<b>Application Ref:</b>	3/2025/0177			 Ribble Valley Borough Council <small>www.ribblevalley.gov.uk</small>
<b>Date Inspected:</b>	10/1/24	<b>Site Notice:</b>	18/4/25	
<b>Officer:</b>	BT			
<b>DELEGATED ITEM FILE REPORT:</b>				<b>APPROVAL</b>

<b>Development Description:</b>	Listed Building Consent for the proposed conversion of Green Barn to create 1no dwelling with associated parking and amenity space. Conversion of Outbuilding 02 to form 2no storage / workshop spaces to serve the proposed barn conversion and Eaves House Farm. Partial Conversion of Outbuilding 01 to form new home office in relation to the existing listed farmhouse.
<b>Site Address/Location:</b>	Eaves House Farm, Waddington Road, West Bradford, BB7 3JF.

Drawing Title
Proposed outbuilding 01 & 02 comprising of new storage / workshops home office and existing wash house.

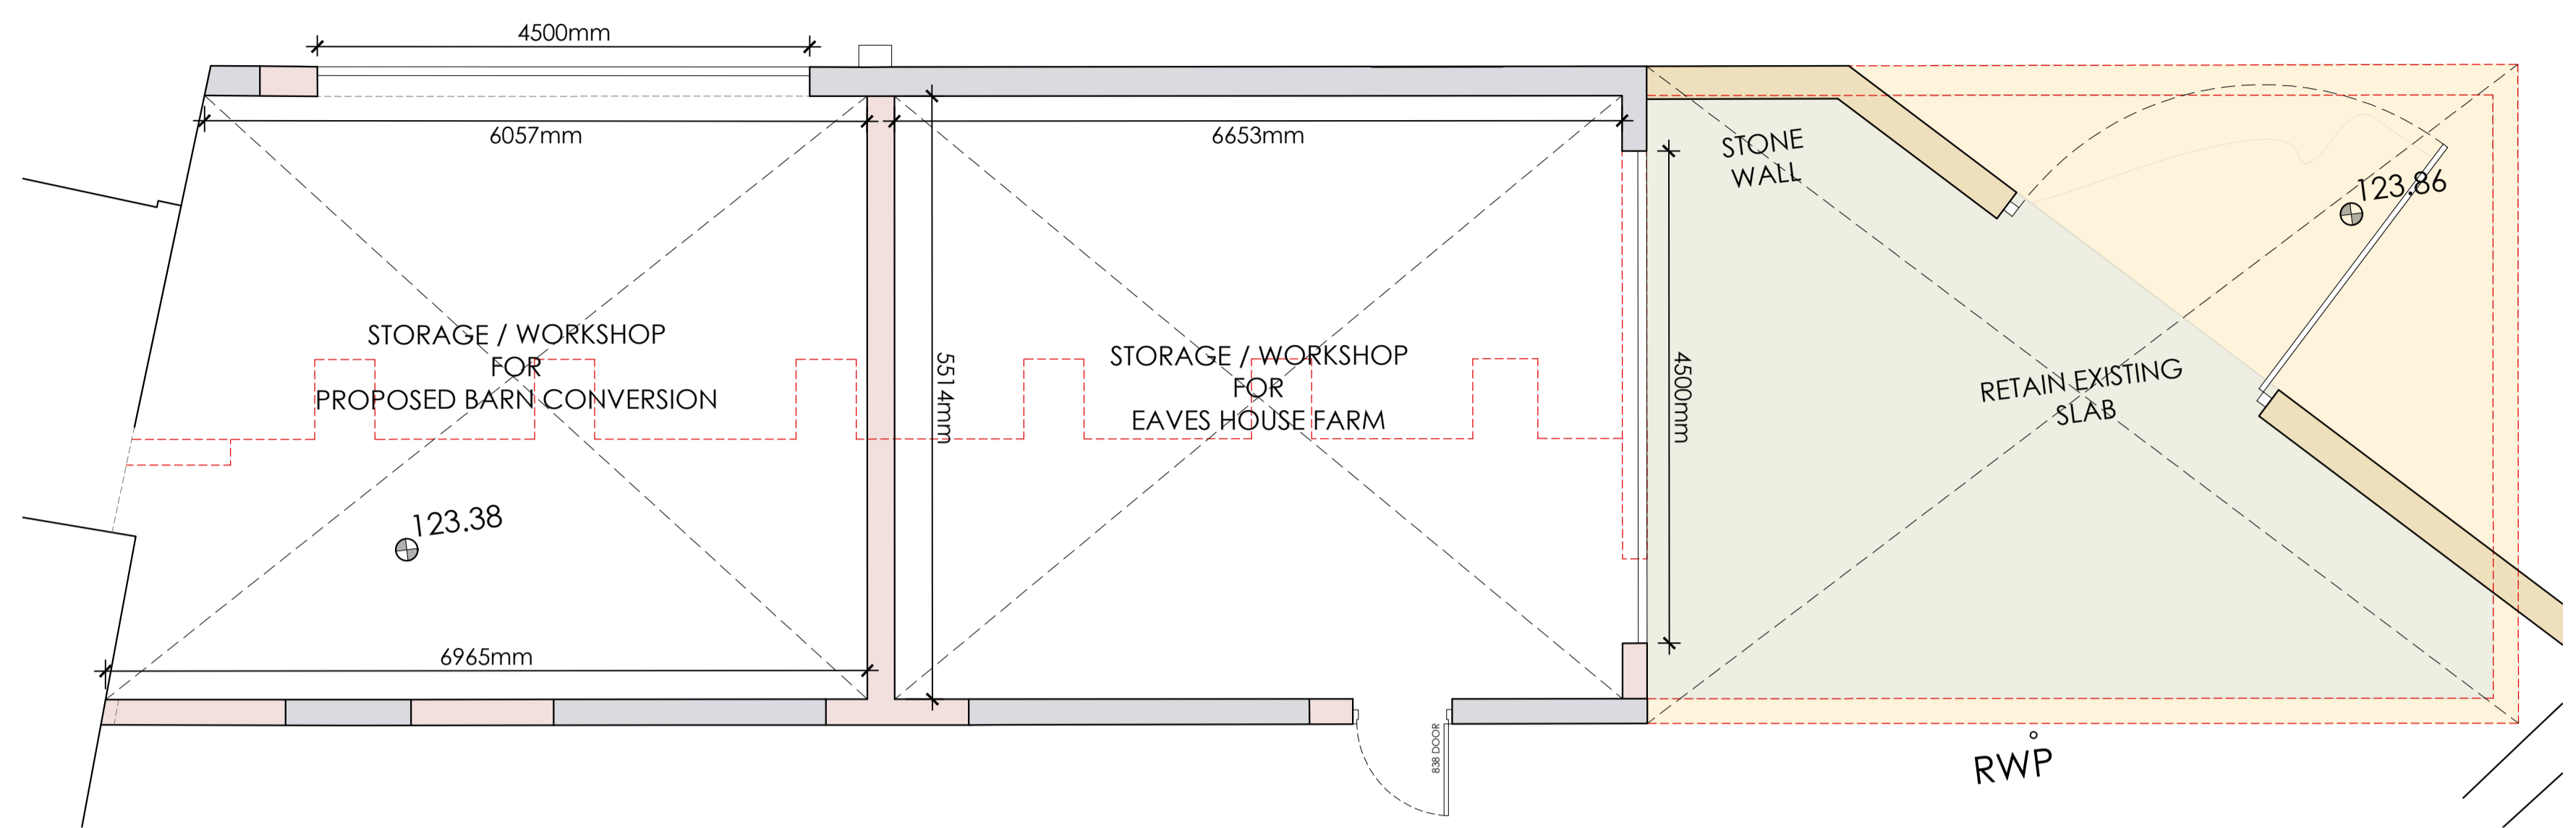
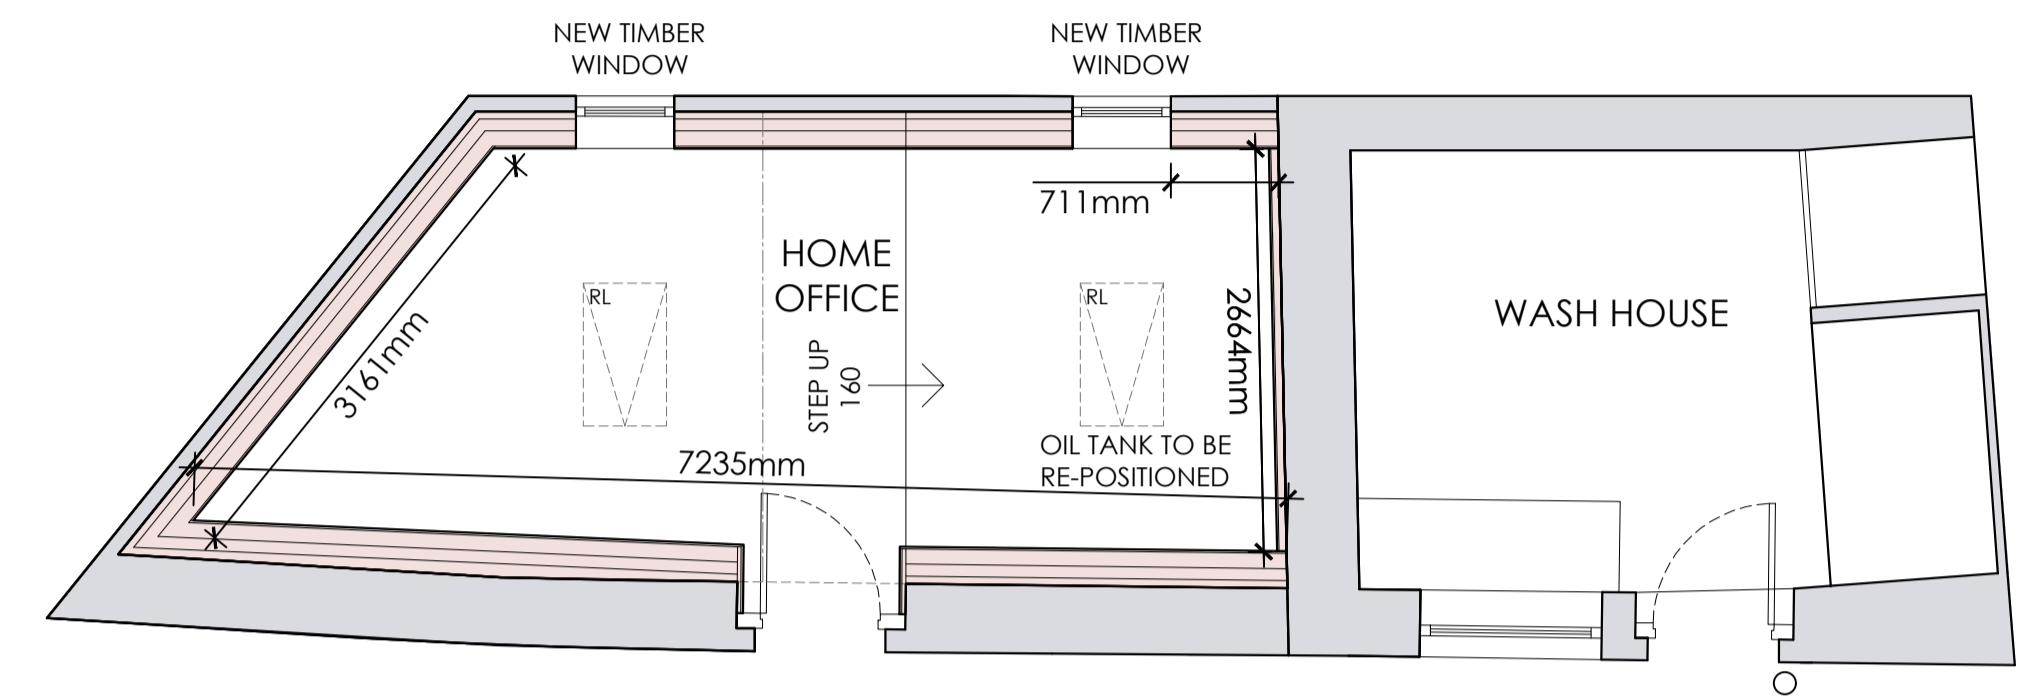
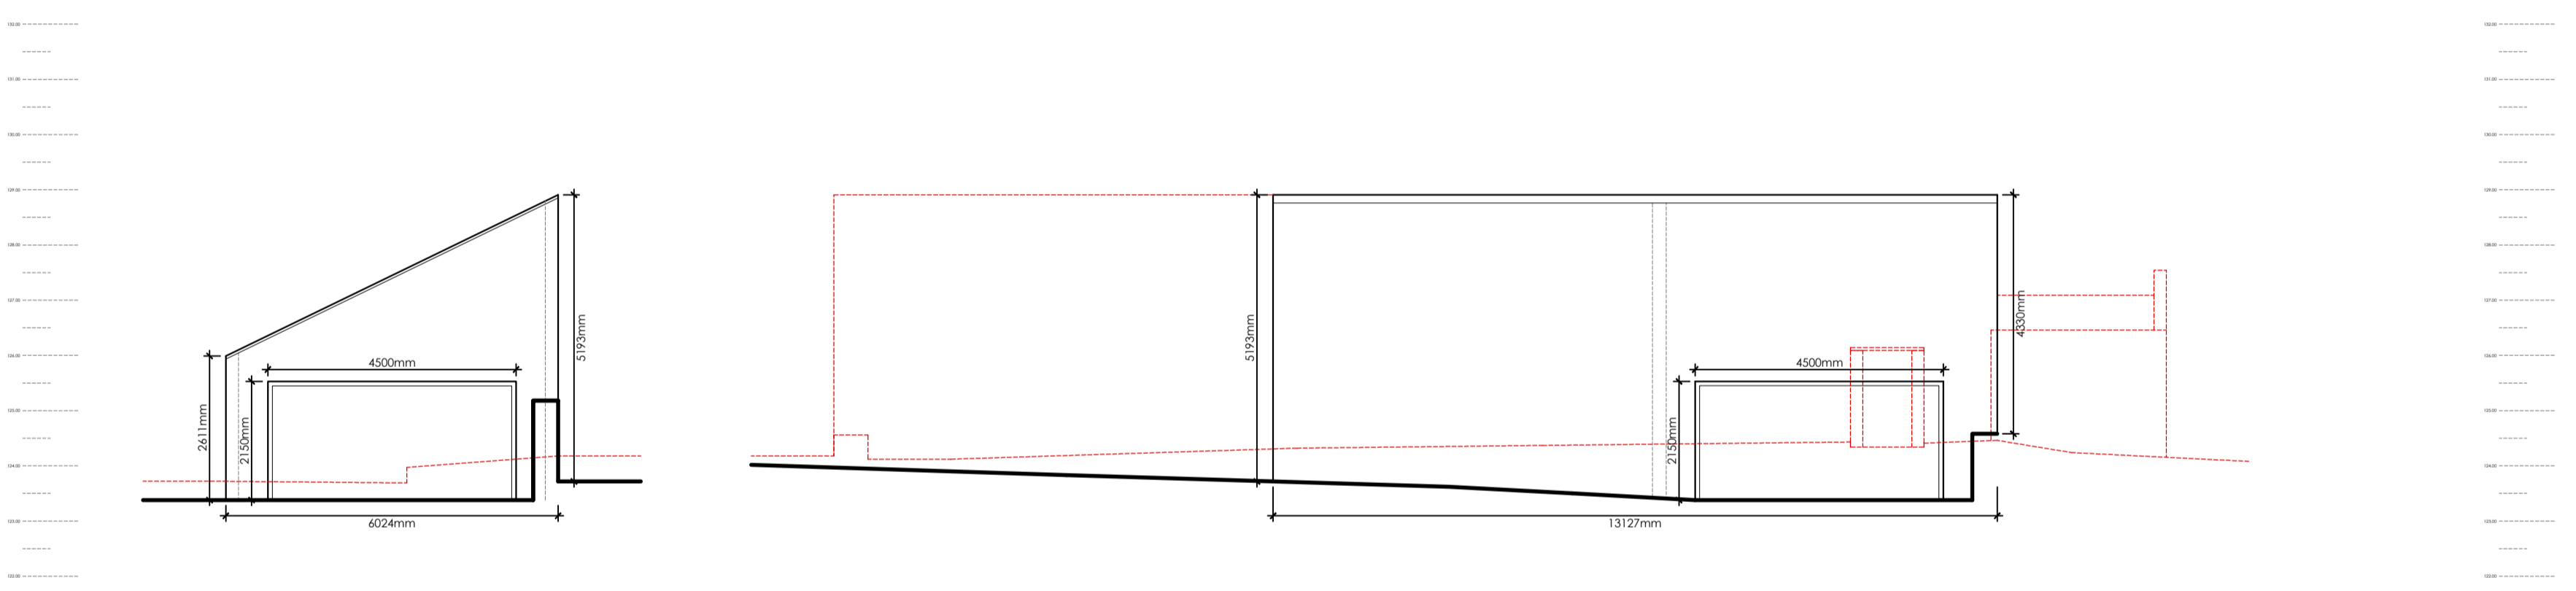
The coal / wash house building adjoining Eaves House (outbuilding 01) currently comprises a hybrid asbestos and slate roof which appeared to be in a partially collapsed state during a recent officer site visit therefore its removal and replacement with a new natural slate roof would deliver a minor visual enhancement to the character and appearance of Eaves House Farm. In addition, the coal / wash house building adjoining Eaves House Farm is a mid-twentieth century addition to the historic farmhouse therefore the proposed replacement of the outbuilding's existing roof and insertion of rooflight and window openings would not result in the loss of any historic building fabric. Furthermore, no alterations are proposed to the plan form of the outbuilding as part of the conversion of its coal house component to a home office therefore the plan form of Eaves House Farm would remain as existing following the proposed works. Moreover, slate roof tiles, conservation style rooflights and timber windows would be utilised as part of the development of the outbuilding, all of which would be respectful to the character and appearance of the adjoining historic farmhouse. The works proposed to outbuilding 01 and are therefore considered to be acceptable, subject to the provision of further details in the form of samples or detailed specifications of the replacement roof slates, elevational and section details of the proposed roof lights (which would need to comprise a conservation style design with a recessed and flush fitting) and subject to the provision of further details with respect to glazing detail, moulding finish and method of opening, fixing and finish for the two new window openings proposed.

PROPOSED ROOF PLAN

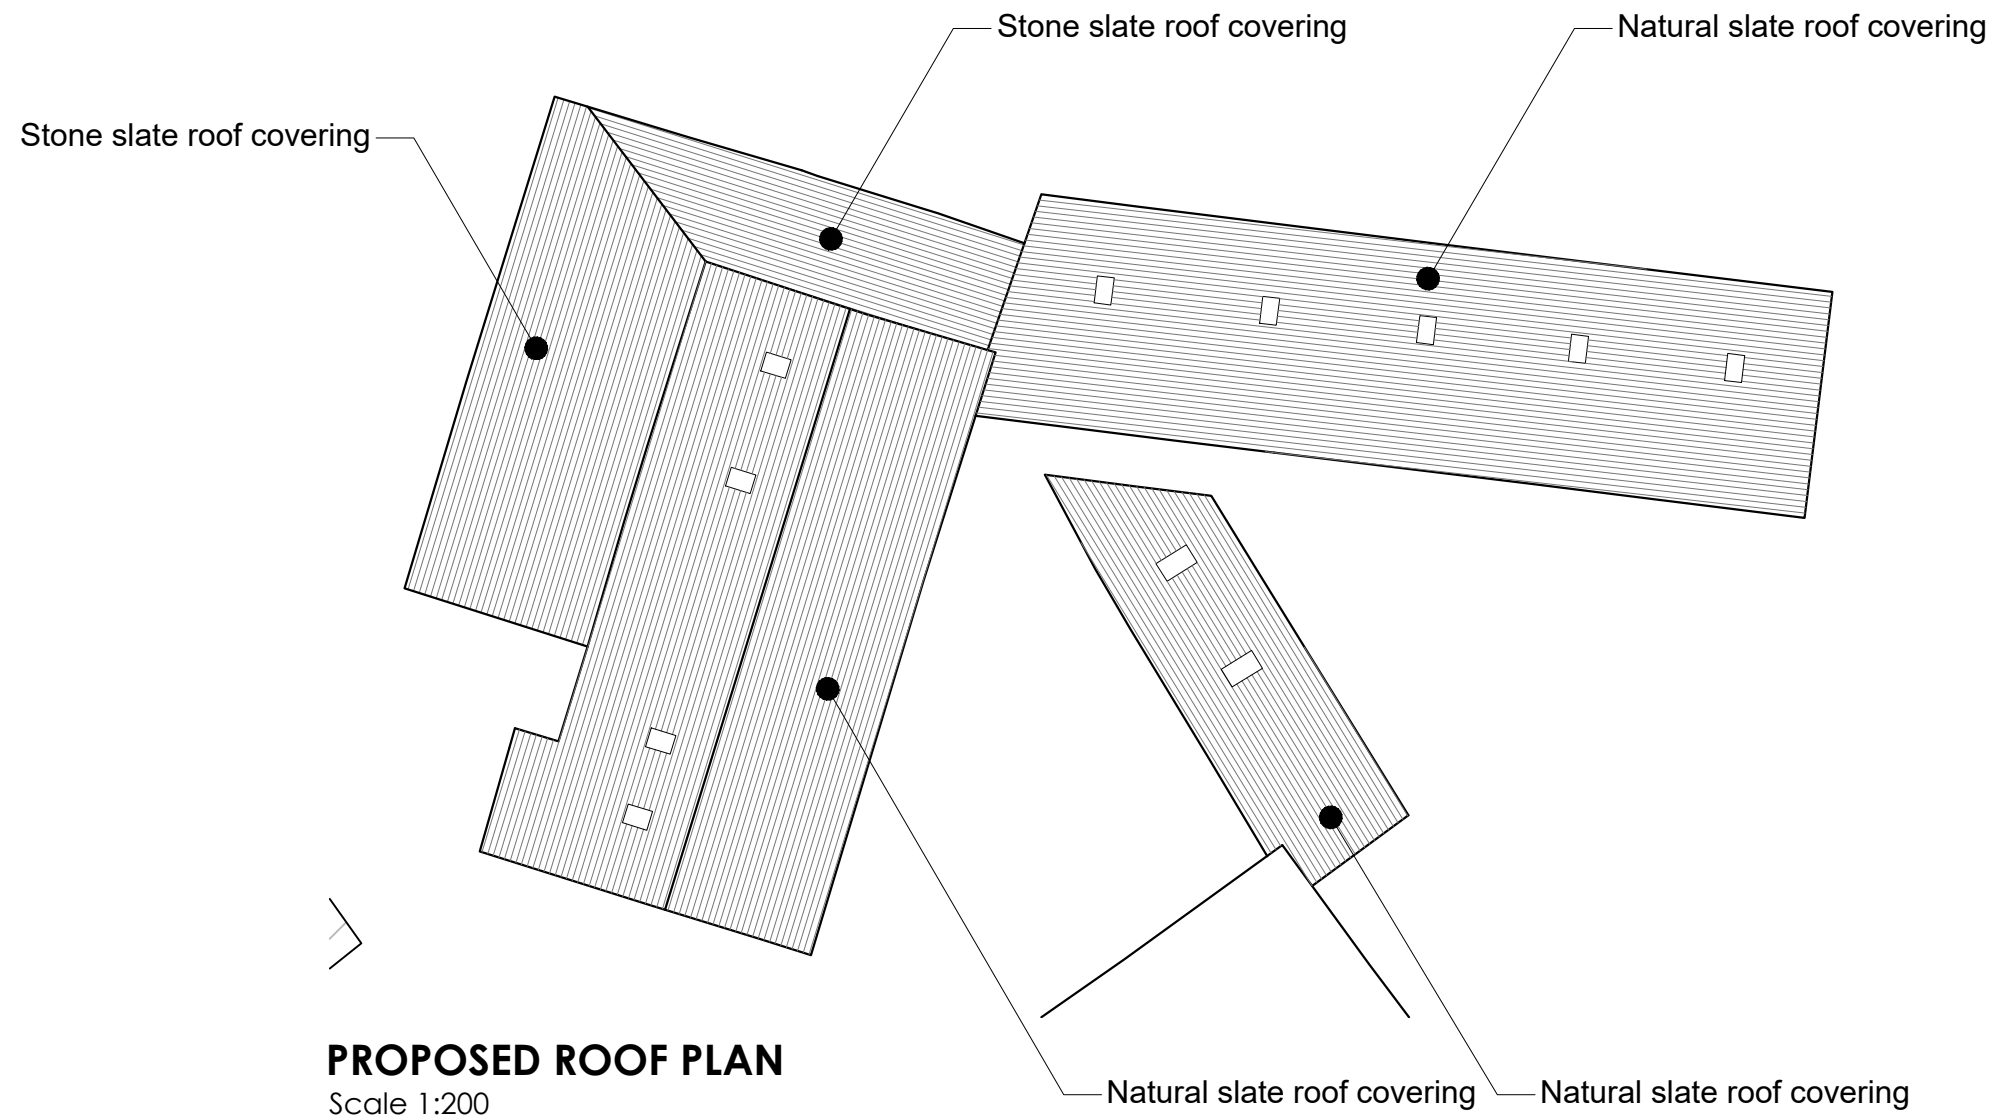
The rooflights proposed for the barn's North-western roof slope would be new additions to the roof of the barn building (which at present comprises no existing rooflight openings) however these would all serve habitable rooms and would be sited in a visually unobtrusive location to the rear of the barn where they would not be readily visible. Furthermore, the applicant has agreed to a reduction in the original number of rooflights proposed (from 9 rooflights to 4) and the proposed roof lights would comprise a conservation style design with a recessed and flush fitting which in turn would minimise their cumulative visual impact and allow for seamless integration with the roof profile of the historic farm building. Moreover, only two of the four rooflights proposed would be sited within the historic

section of the barn's roof (the two Westernmost rooflights would be installed within the new section of slate roofing) therefore the resultant loss of historic building fabric arising from the introduction of the proposed rooflights would not be significant. Accordingly, it is not considered that the introduction of the proposed rooflights would be unduly harmful to the significance of the heritage asset and these works are therefore considered to be acceptable, subject to the provision of further details with respect to elevational and section details, and on the basis of the proposed roof lights comprising a conservation style design with a recessed and flush fitting.
